From: Anna Appleton
Sent: 27 March 2019 12:03
To: Simon Davis <Simon.Davis@arun.gov.uk>
Subject: RE: Planning Consultation on: BR/39/19/PL

BR/39/19/PL - Application for Variation of Conditions following the grant of Planning Permission BR/240/16/PL relating to Condition 2 & Planning Permission BR/331/17/PL relating to condition 1 - approved plans

title: Proposed Site Elevations
status: Aug 2016
date: 1:500 @ A1
scale: MH
drawn: CE
chk'd:

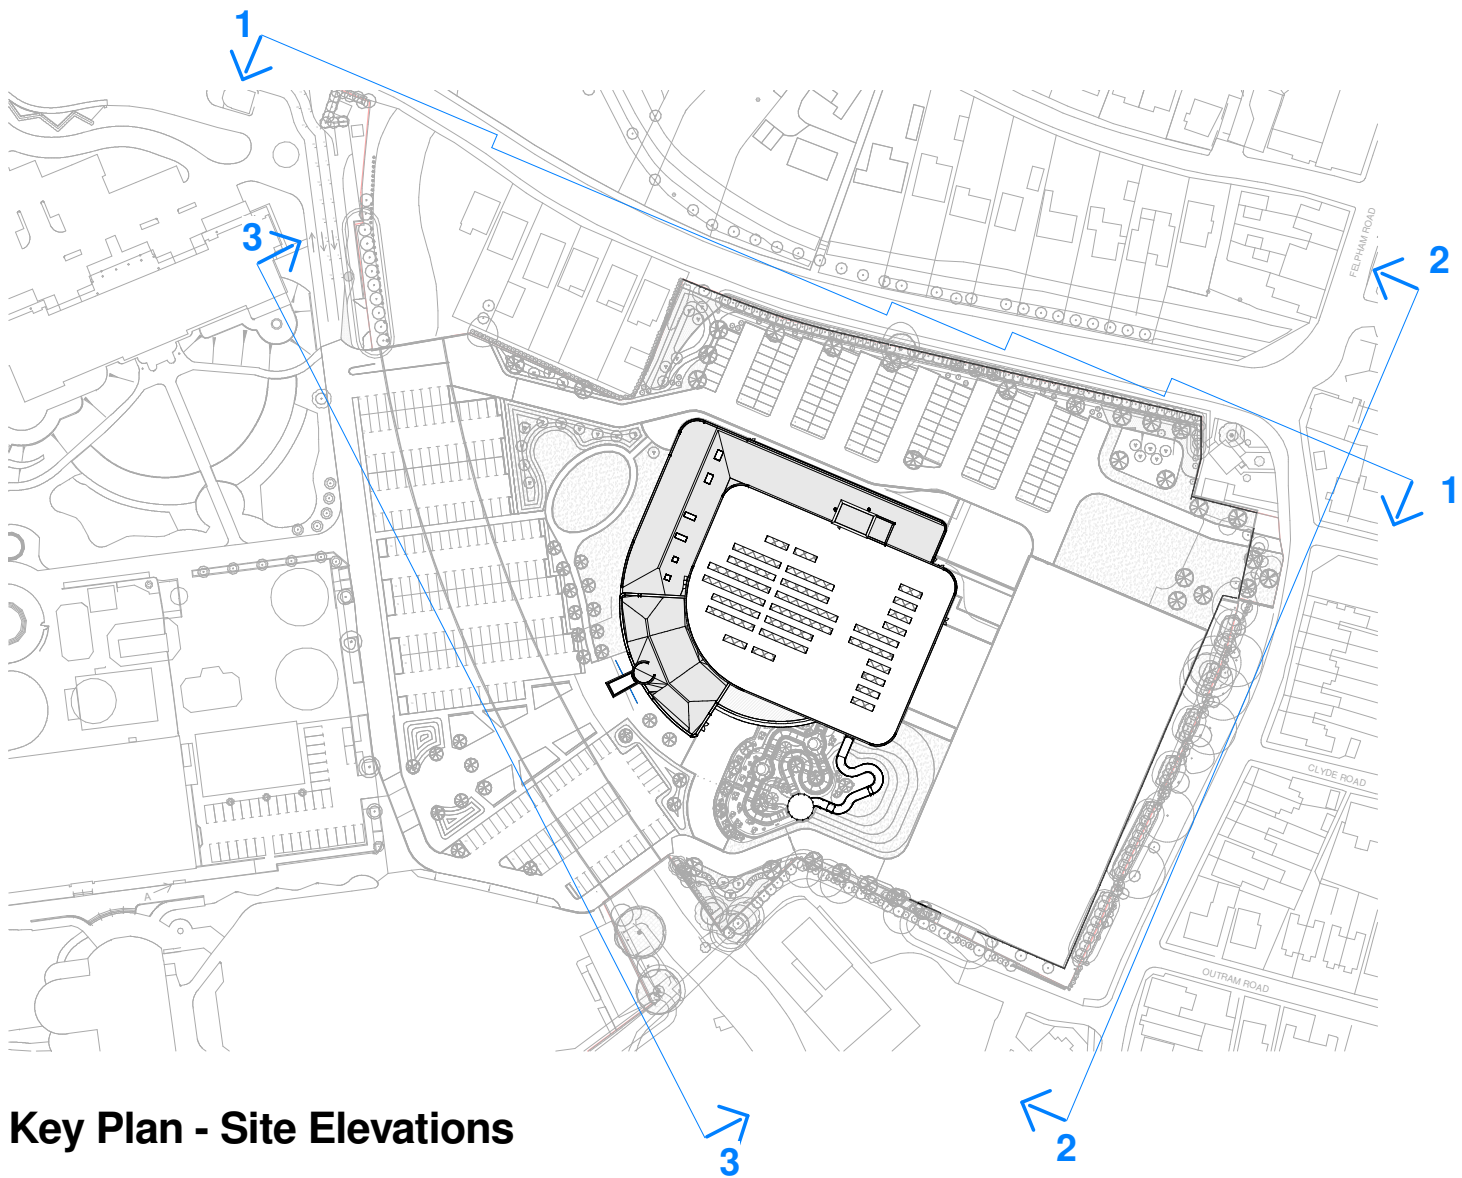
Please see comment below from Environmental Health. Can you advise re whether the amendments to the flume height and the rapid river design will have any adverse impact on the acoustic environment.

I note from the covering letter submitted with the application that it includes amendments to reduce the height of the flume, adjustments to the design of the rapid river and addition of louvres. They have stated that the louvres will have no impact on the acoustic performance of the building. However, I would request that the applicants also ask their acoustic consultant to confirm that the amendments to the flume height and the rapid river design will have no adverse impact on the acoustic environment. If this is the case then environmental health would have no objection to the amendments.

Attached is an email from the acoustic consultant (who prepared the original 2016 report) providing confirmation that his conclusions do not change. That is, the minor amendments to the flume height and the rapid river design proposed by this application will have no adverse impact on the acoustic environment.
